Subject: FW: BN/18/20/PL, Former Brooks Nursery

Please Upload the below and attached to the above application: additional information(drainage)

In terms of the proposals effect on the existing suds (surface water drainage system), I would like to make the following comments;

A	21.05.19	Bellmouth amended	HJS
REV. No.	DATE	DESCRIPTION	INITIALS
Client	 BARRATT HOMES		
Project	Brooks Nursery Barnham		
Title	Foul Outfall Rising Main Details		
Scale	1:250	Date	Sept '18
Checked	AMc	Drawn	AMc
Drawing No.	4482:510	Rev	A

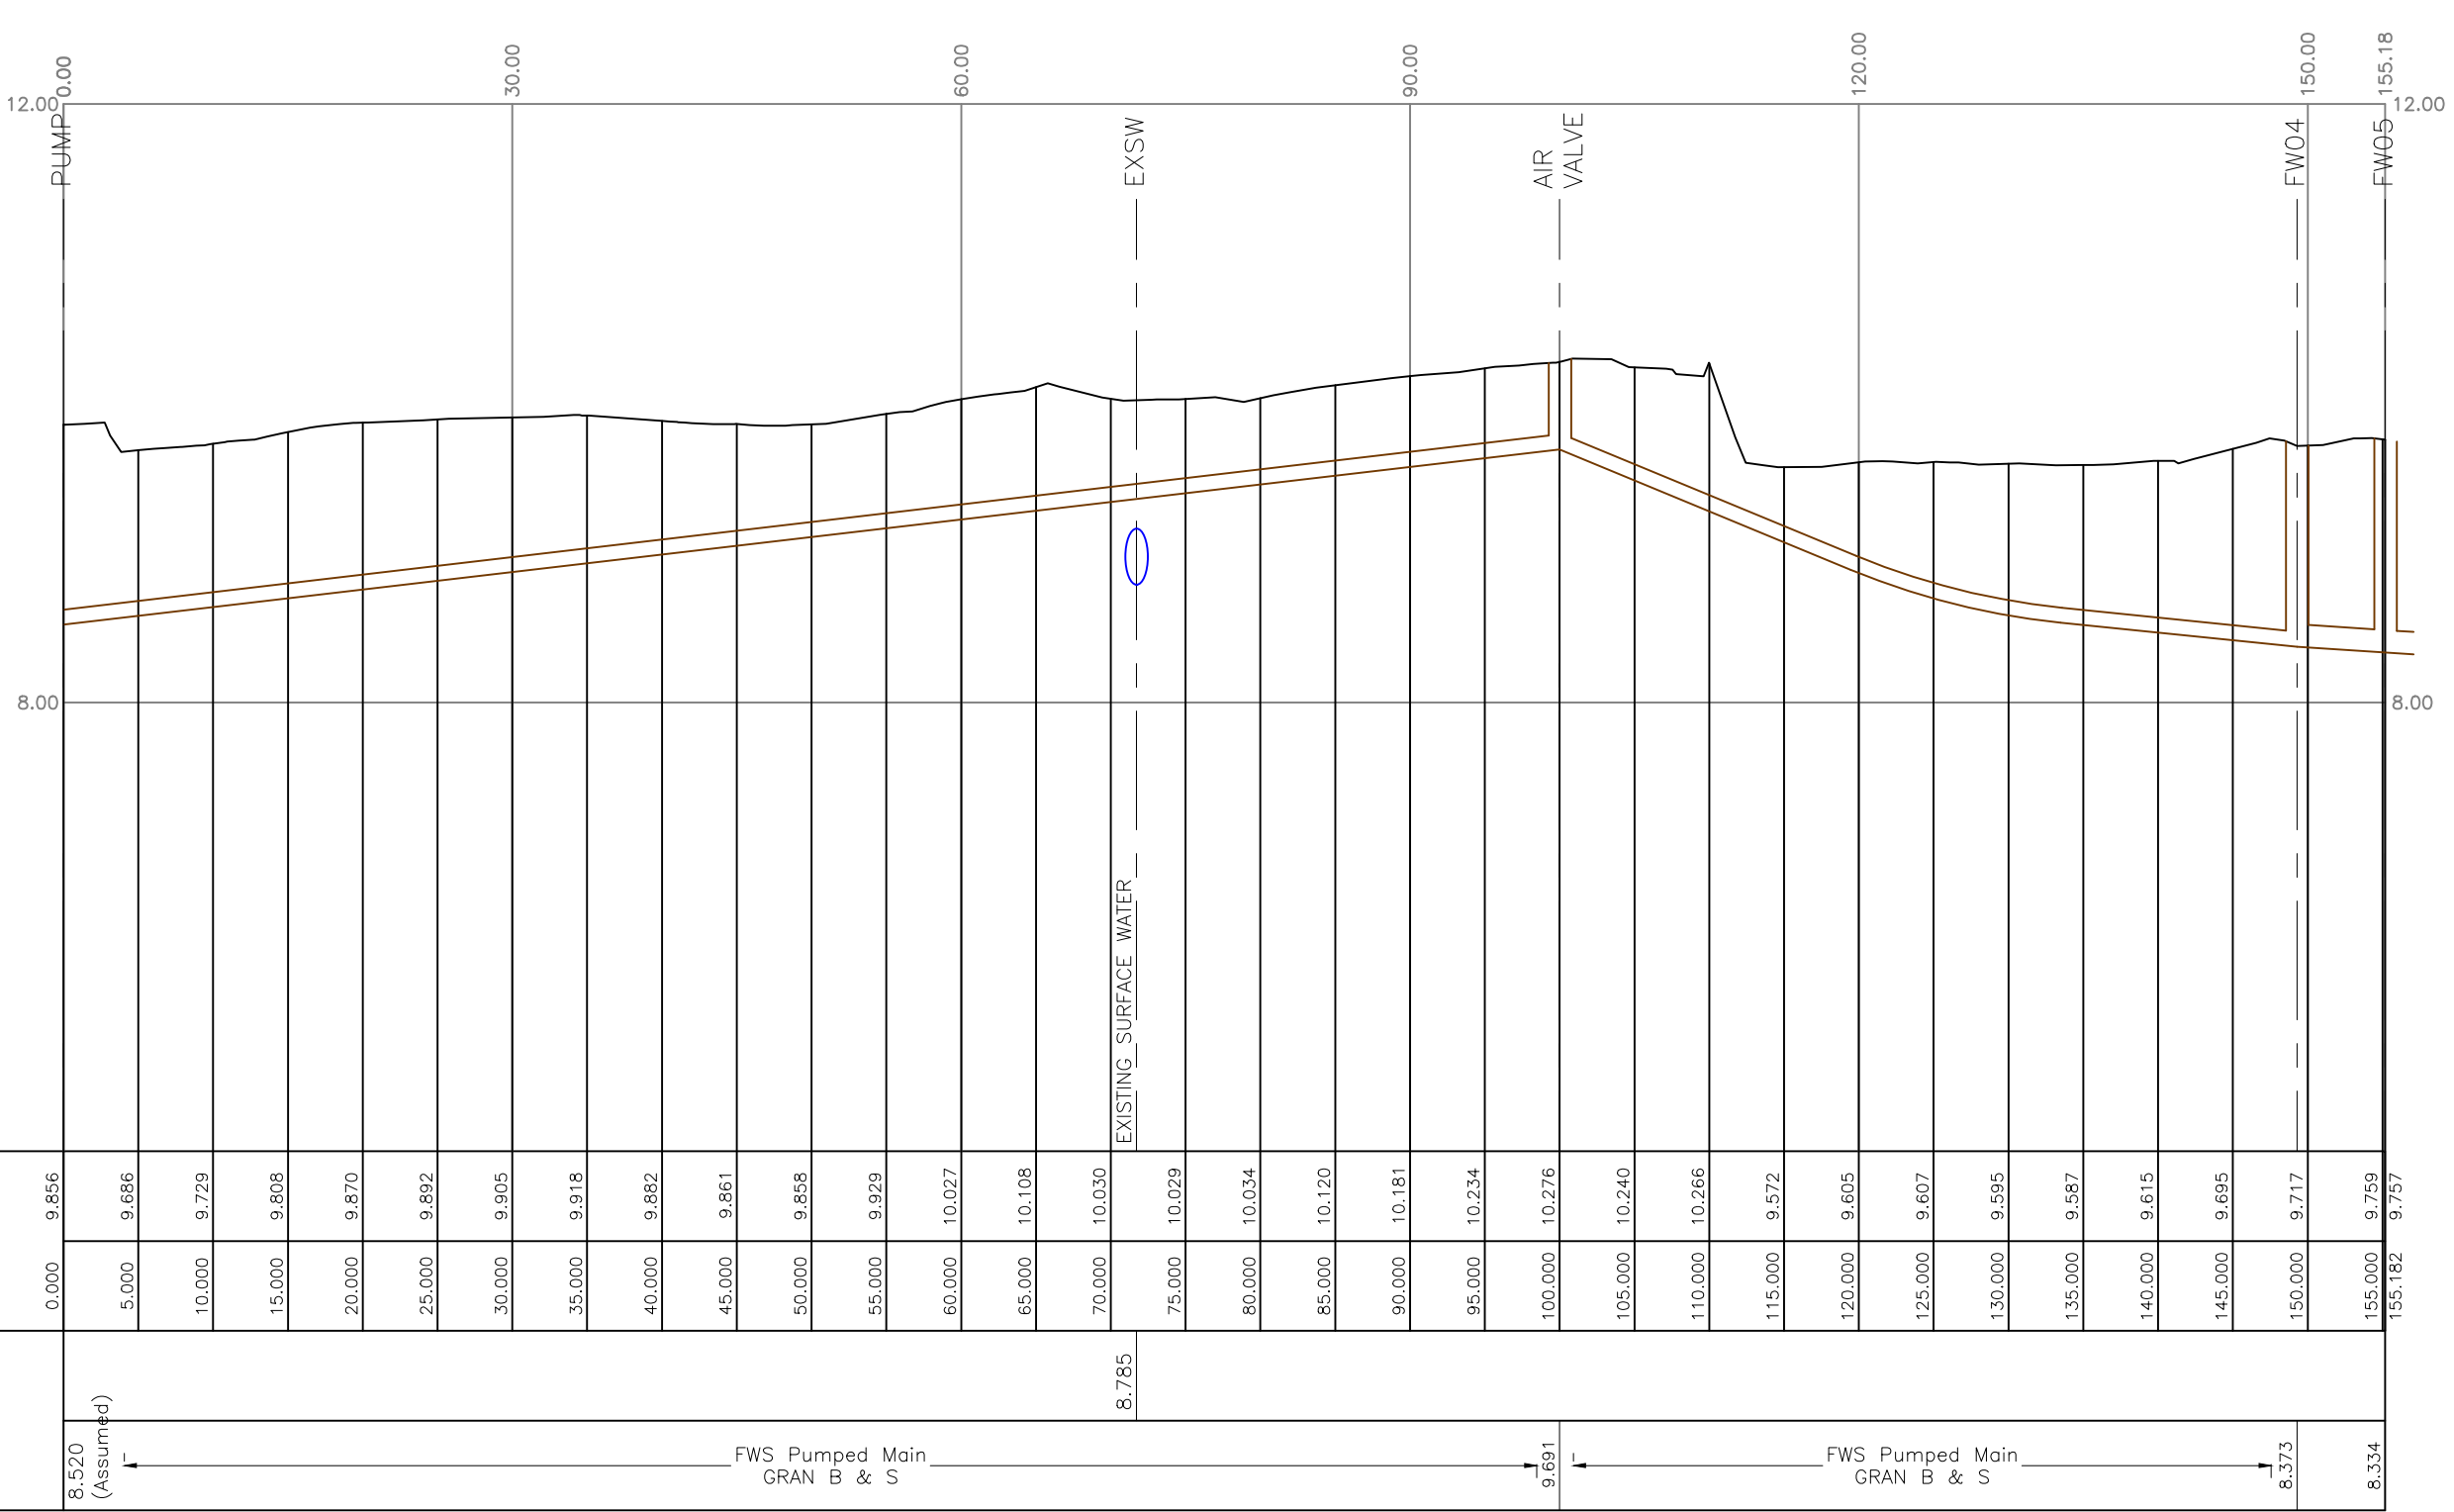
- a) The open channel/ditch in which the sewage treatment plant discharges into at present, before it connects into the suds pond, is proposed to be infilled.
The applicant will need to provide written confirmation with supporting calculations to prove that the storage for surface water within the suds system is not compromised as a result.
- b) Where the proposed rising crosses the incoming surface water outfall to the pond and the known land drain running parallel to the eastern boundary of the development, the applicant should provide a longitudinal section to prove no impact on these pipelines.

Finally, the long section requested was already shown on drawing no, 4482.510A , which I attach for reference along with the other engineers drawings which were agreed at the meeting
